**ADDENDUM TO REPORT OF IAN PICKLES, EXECUTIVE PLANNER
DATED 12 OCTOBER 2010**

SUBJECT: PDS07 – 6-16 ATCHISON STREET, ST LEONARDS
PART 3A DEVELOPMENT

APPLICATION NO: NSW DEPARTMENT OF PLANNING REF: MP 09_0187

Figure 3: Proposed built form (reproduced here)

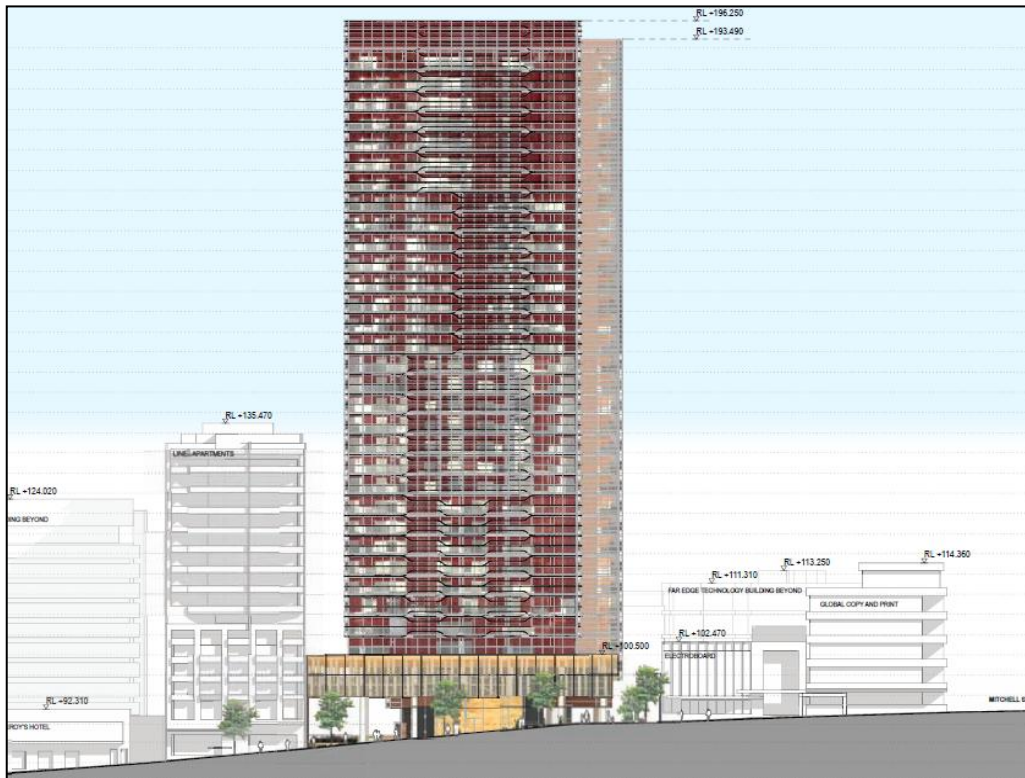
The Panel considers that more work is required on the floor plan of the tower and the floor plate of the tower needs to be reduced further to ensure compliance with the rule of thumb recommendations under the RFDC. The full development potential of adjoining sites must be maintained.

The Panel considers that any built form that does not step down from the Forum in keeping with Council's stated policy is unacceptable regardless of amenity and other concerns. The proposed 109m tower is not supported by the Panel.
